Recommendation Report for Planning Permission for Works or Extension to a Dwelling

REF NO: AW/235/19/HH

LOCATION: 43 St Peters Close
Aldwick
PO21 5QA

PROPOSAL: Front porch extension.

PROPOSED GROUND FLOOR PLAN

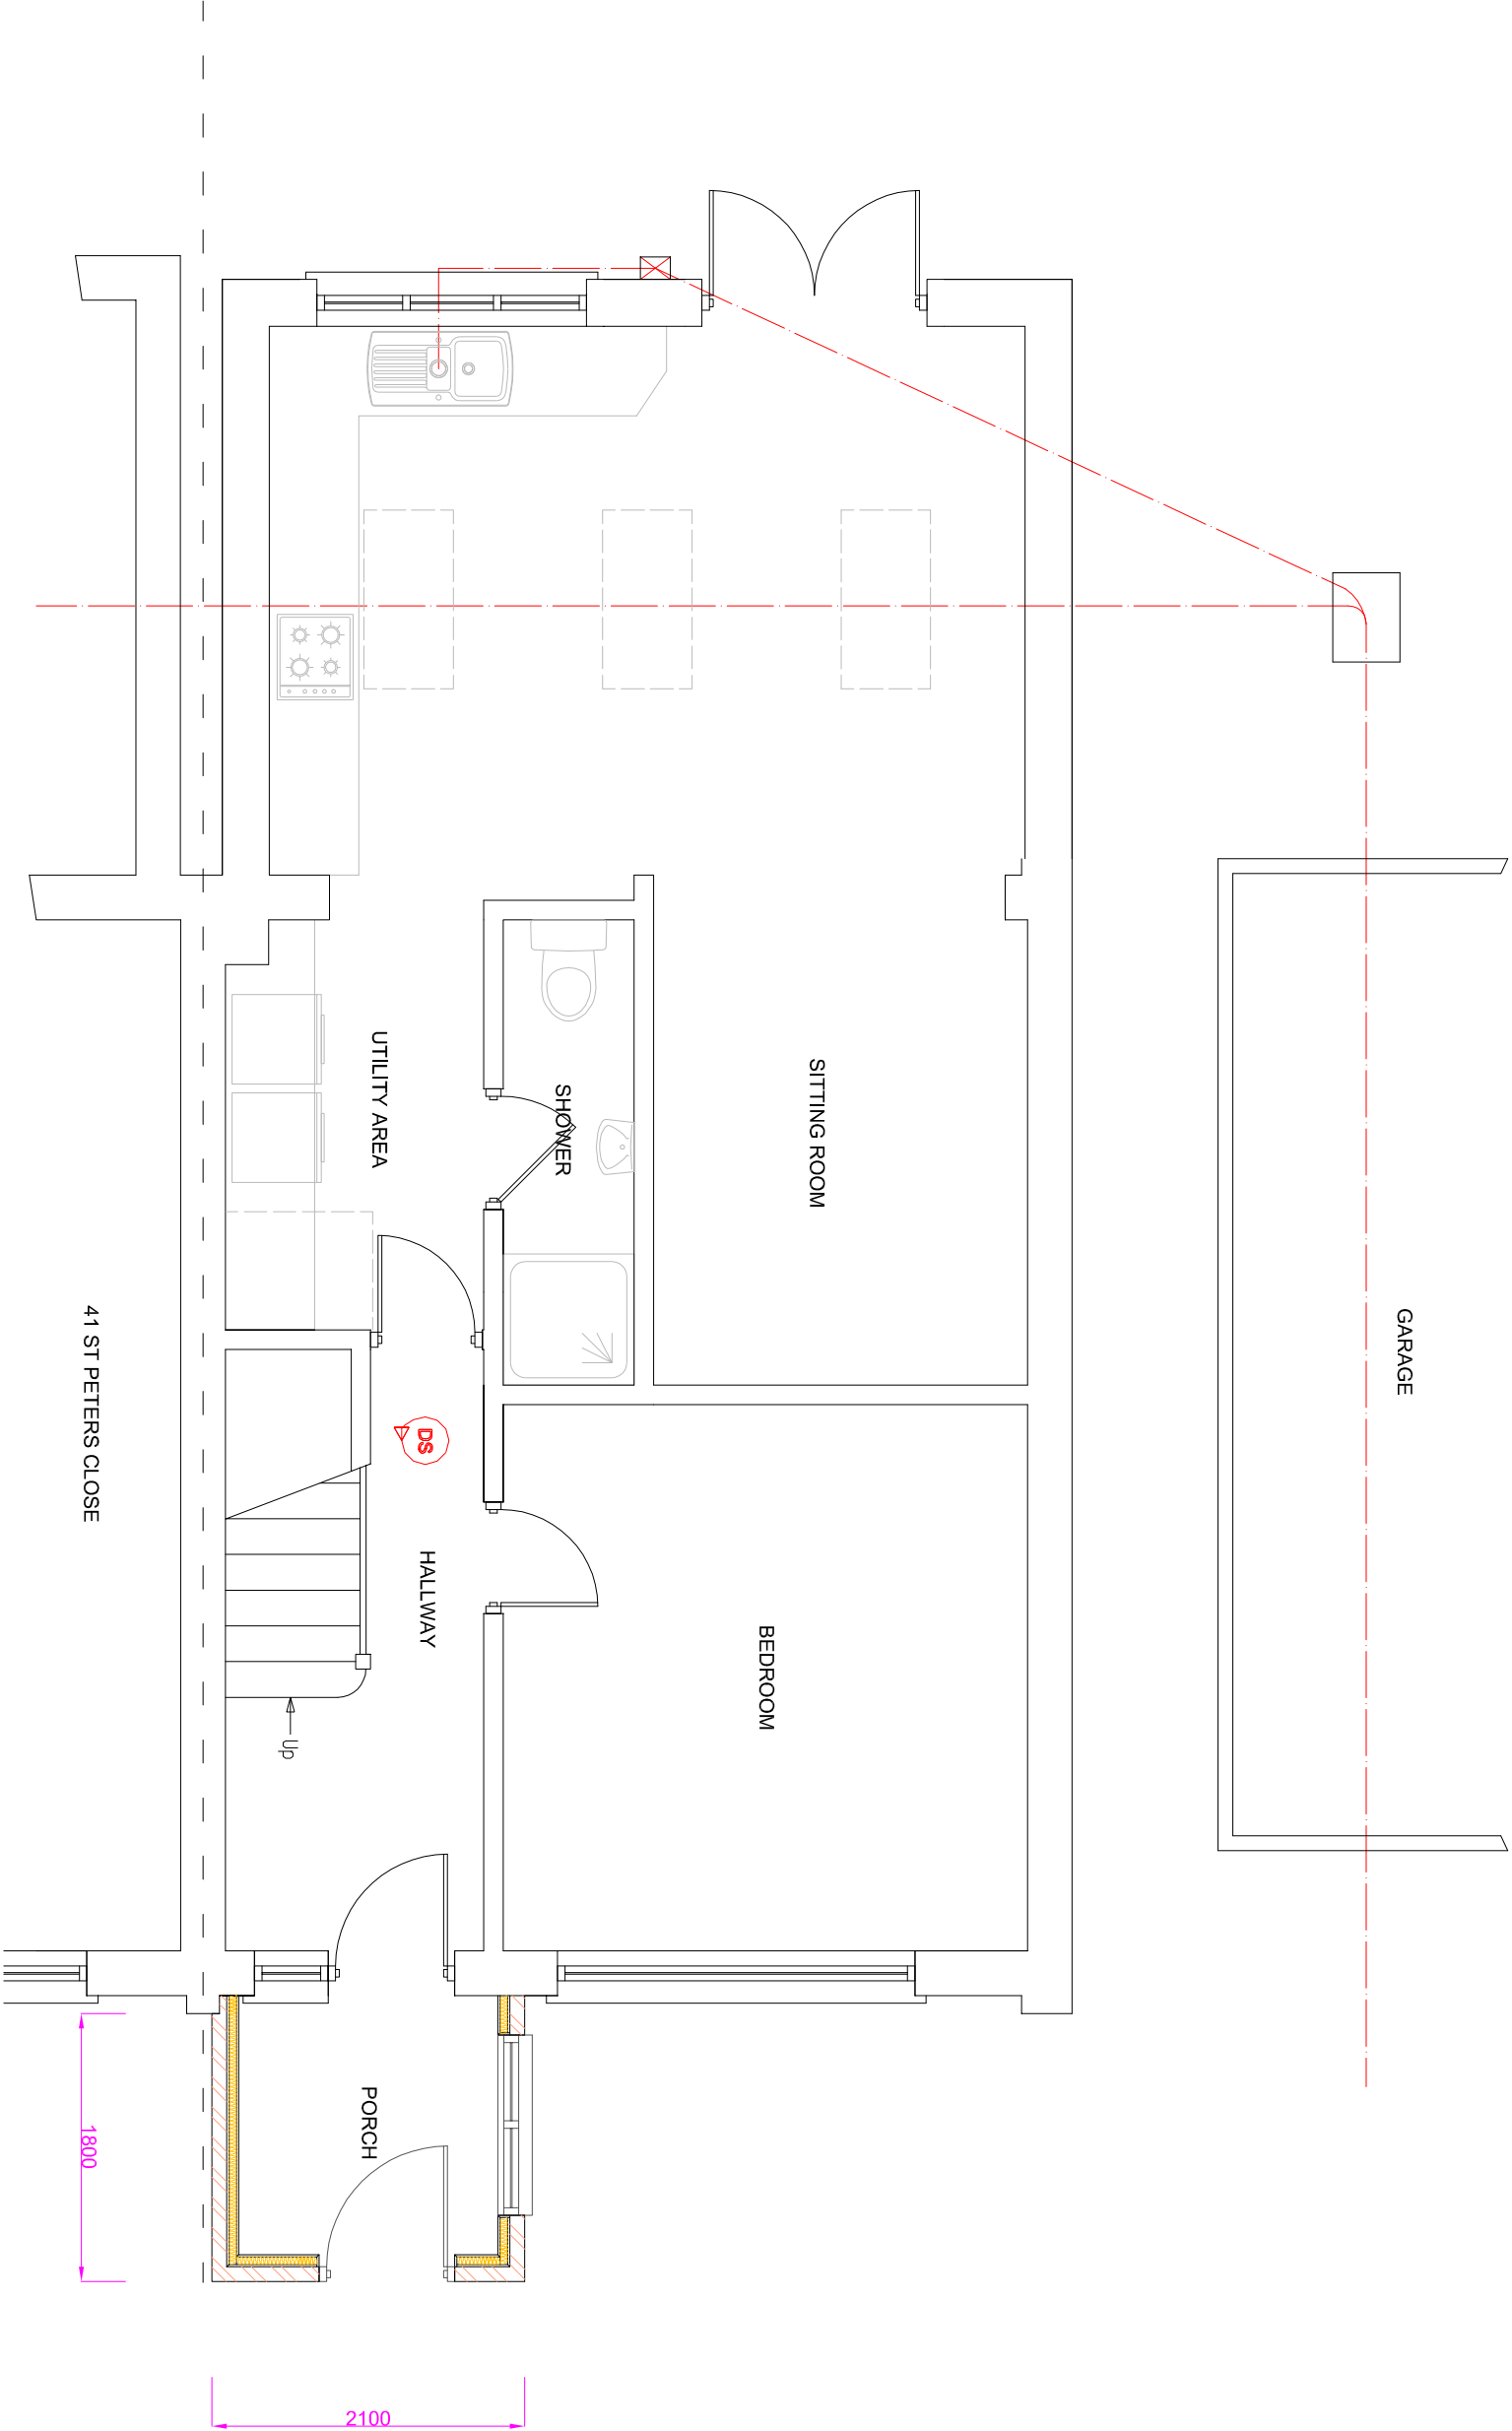
The porch is sited to the front elevation and as such will be visible from the street scene. The surrounding properties are similar in style and design, however the neighbouring property at No.41 also has a porch extension and therefore the proposal cannot be considered out of character.

The porch is modest in size with a depth of 1.8m and a width of 2.1m. 6m is retained to the front boundary and due to its design it is not considered to appear overly dominant to the front of the property.

PROPOSED ELEVATIONS

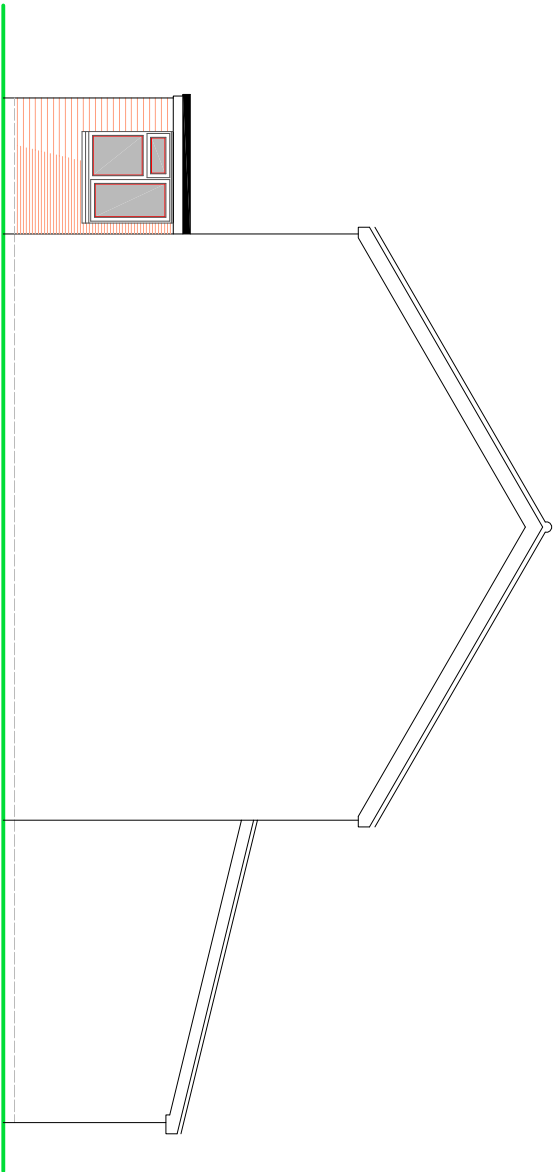
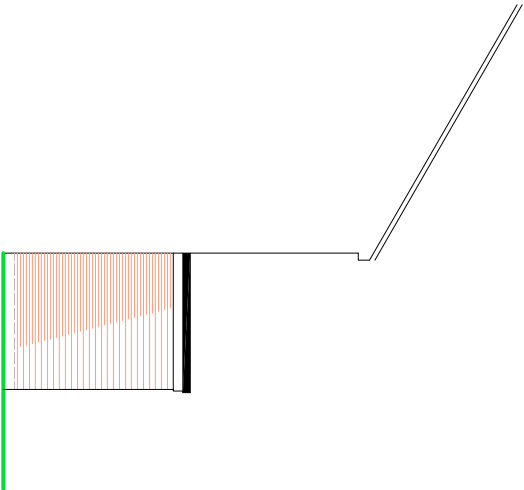
The extension is situated to the north eastern boundary with a depth of 1.8m. It will be constructed to a height of approximately 2.5m with a flat roof.

As a result of the siting and depth, the addition does not intersect a 45 degree line when draw from the centre of the window at the front elevation of the neighbouring property at No.41.
